Eldorado Springs at Cheyenne Mountain Fil. No. 1

ADMINISTRATIVE SITE DEVELOPMENT PLAN - ARCHITECTURAL FOOTPRINTS

Footprints_V2.pdf Markup Summary

ADMINISTRATIVE SITE DEVELOPMENT PLAN - ARCHITECTURAL FOOTPRINTS

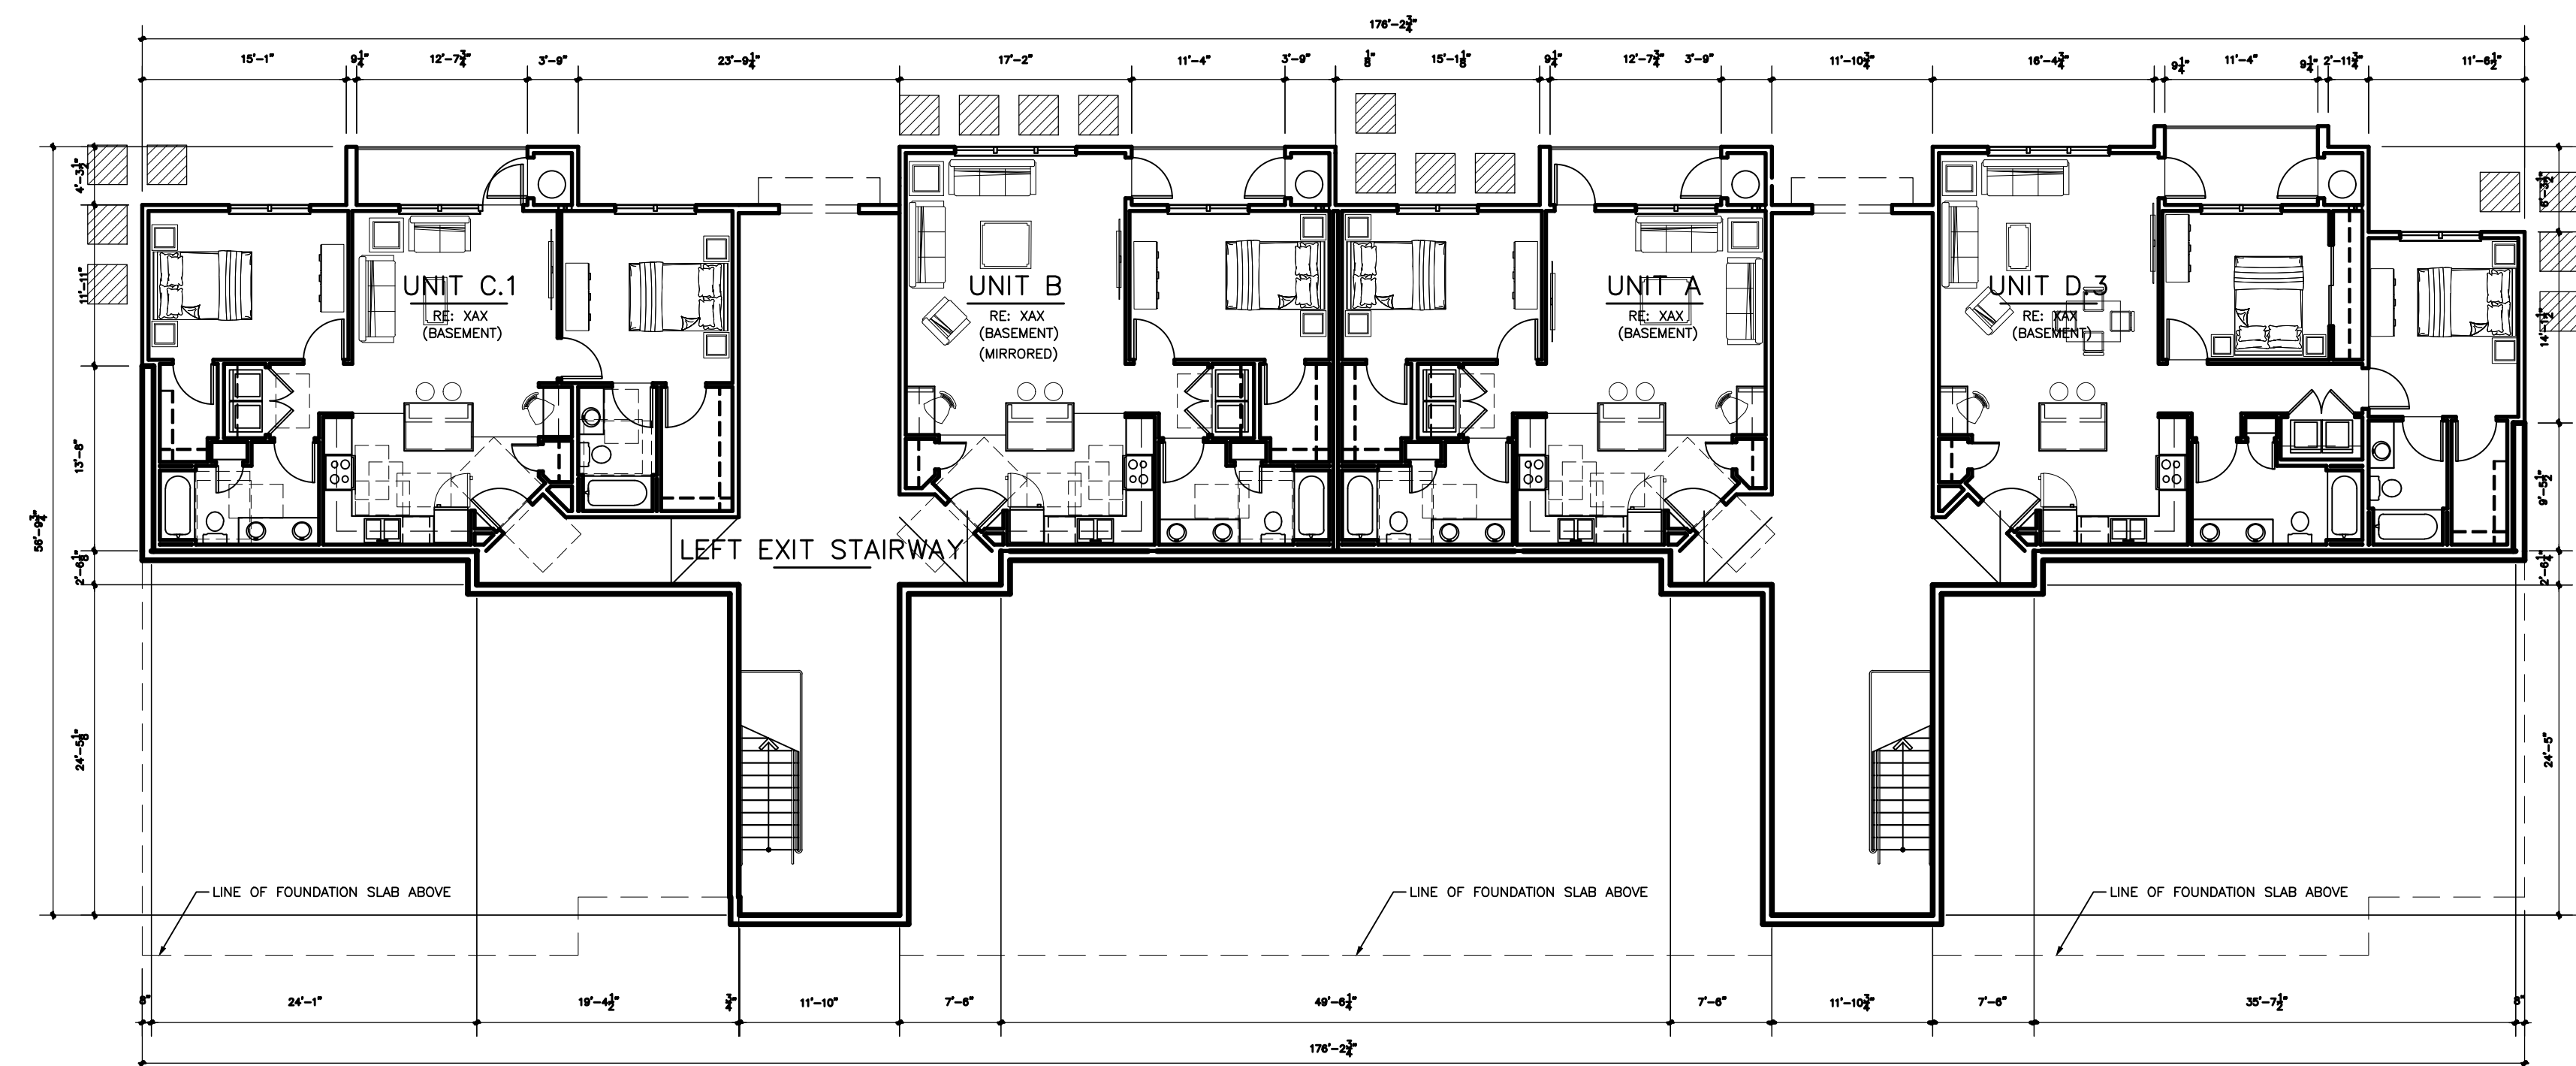
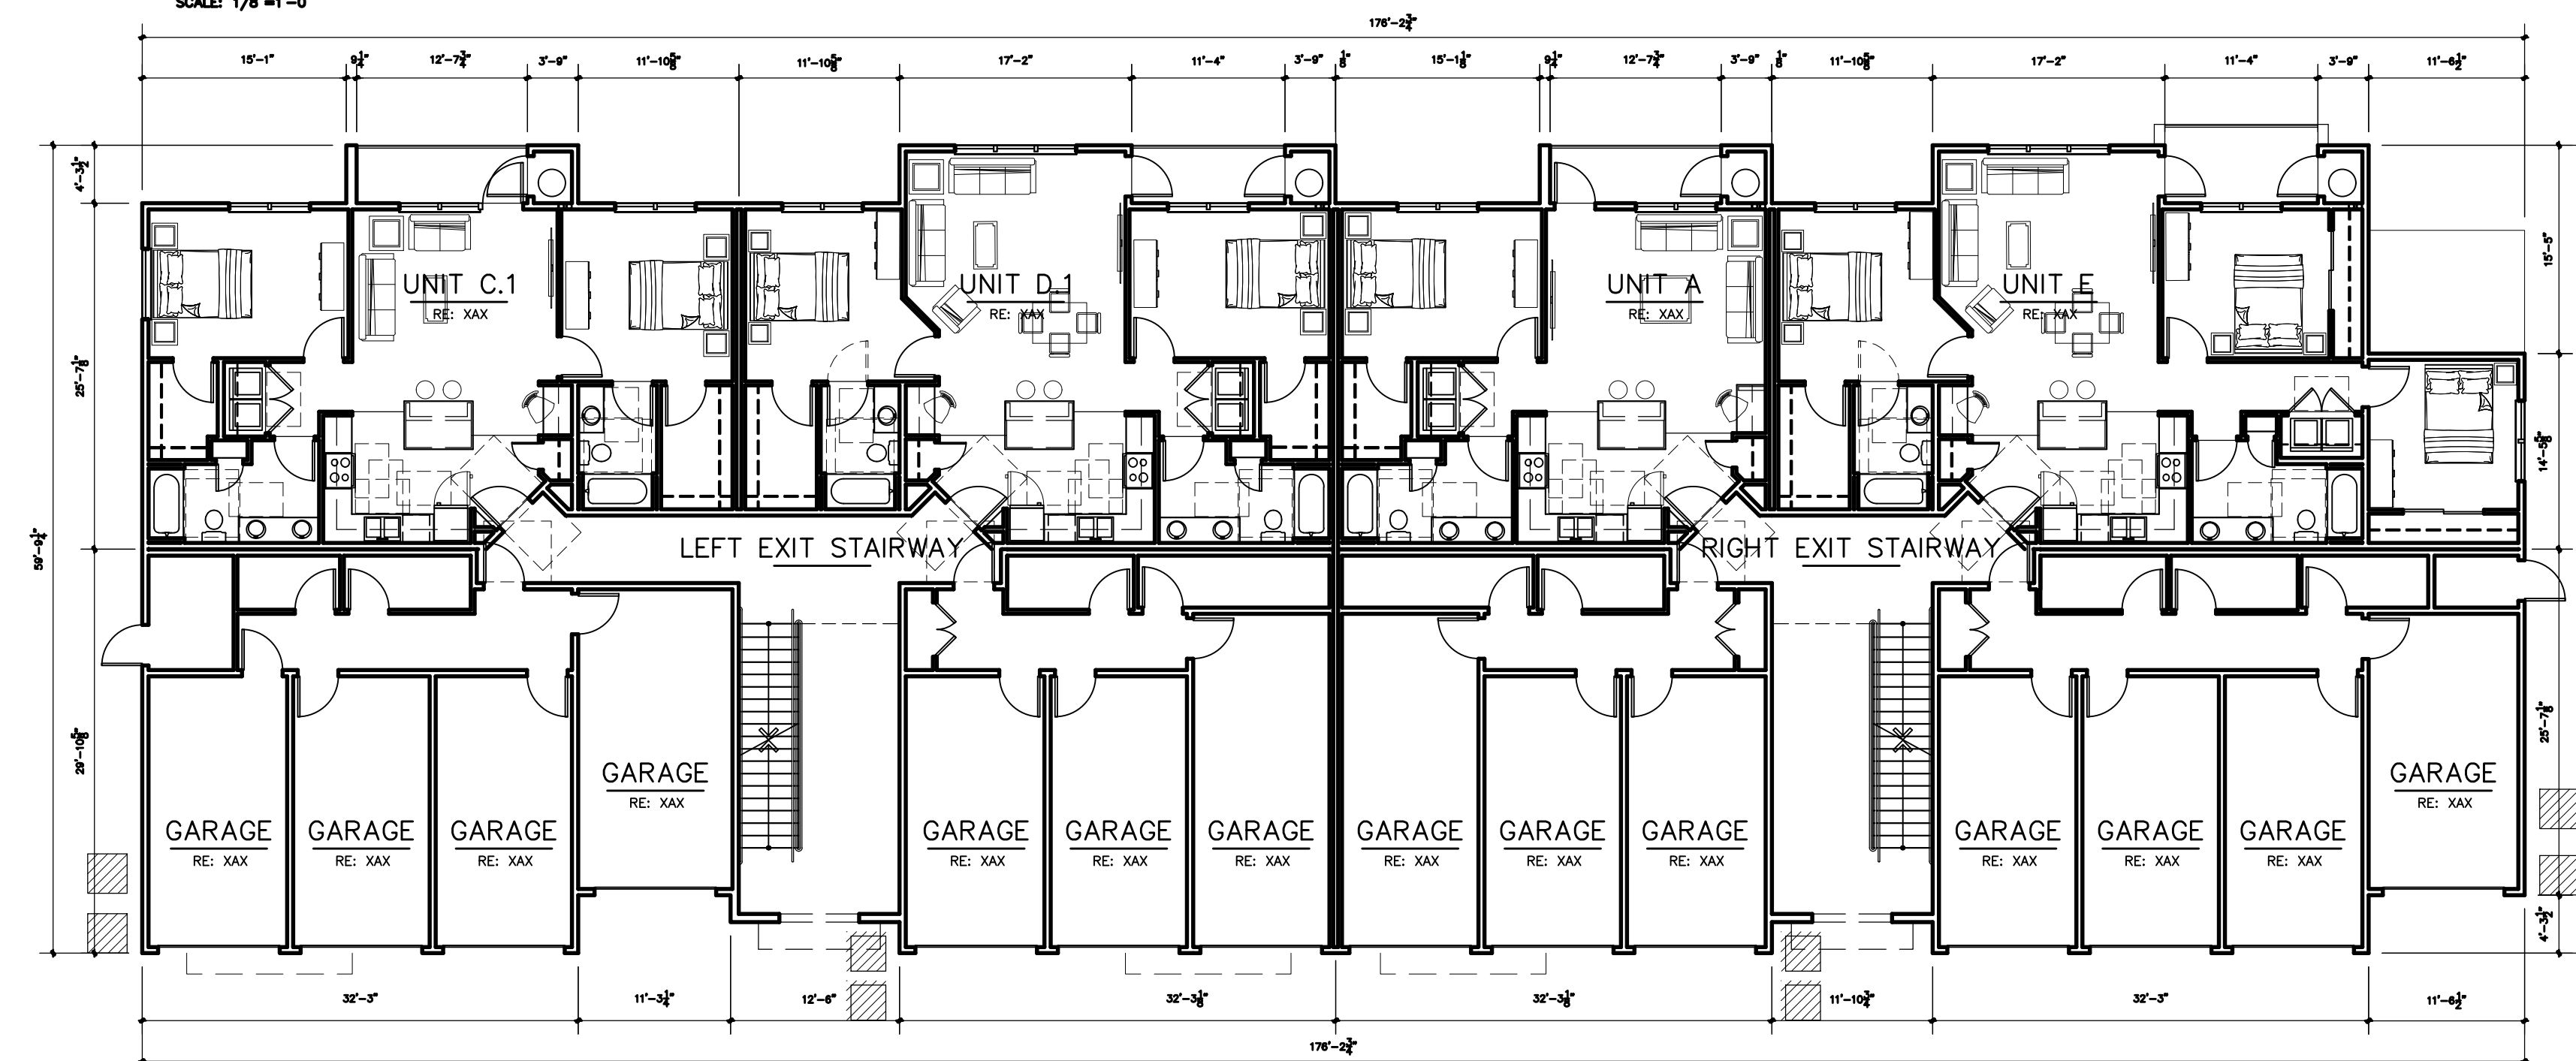
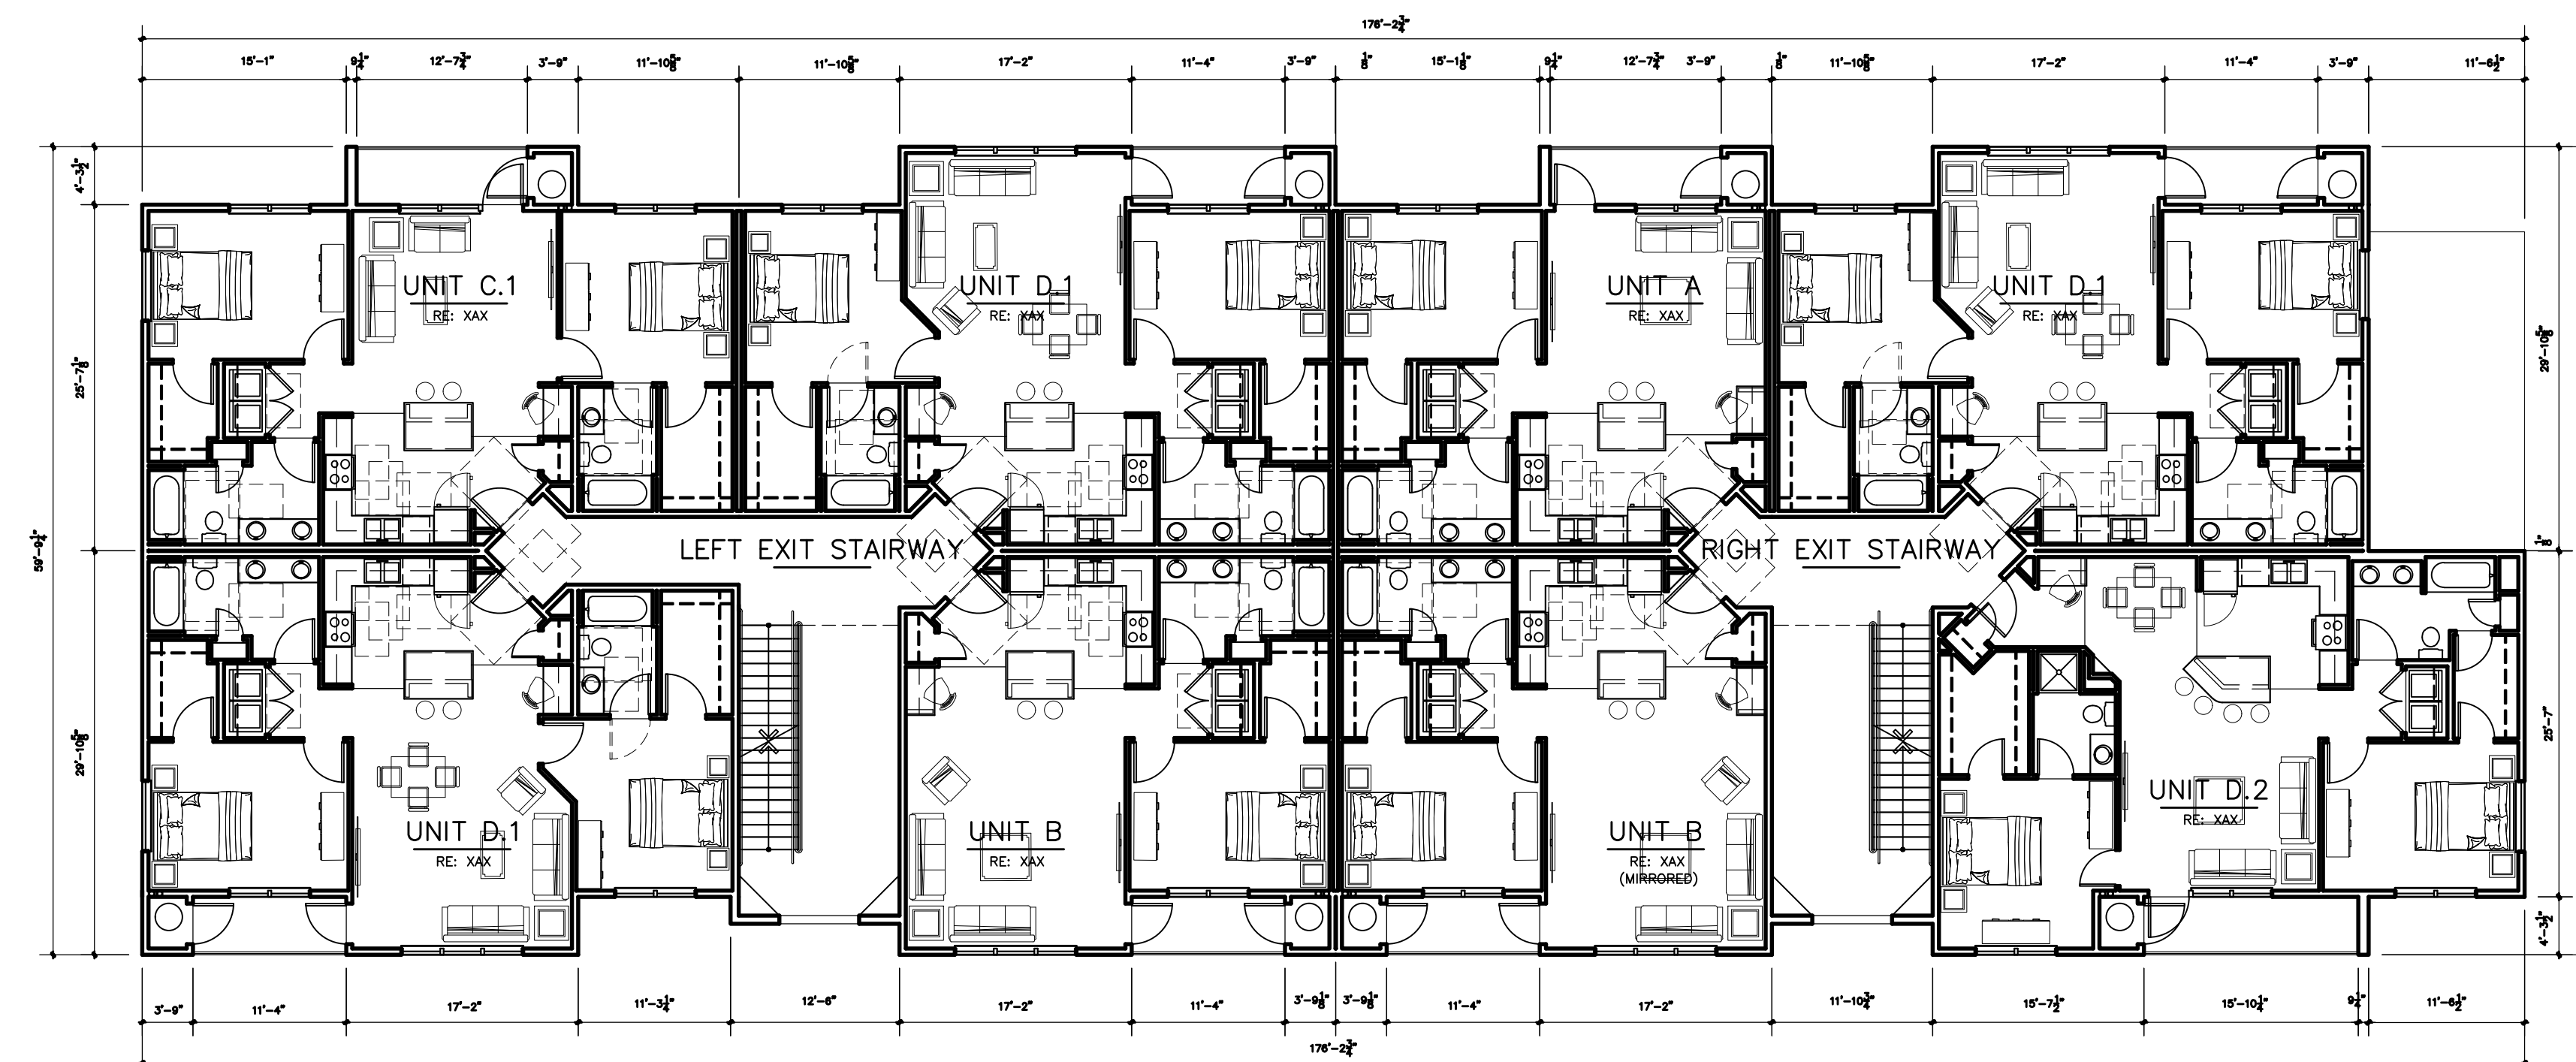
update, needs to be INDEPENDENCE PLACE AT
CHEYENNE MOUNTAIN FIL NO 1
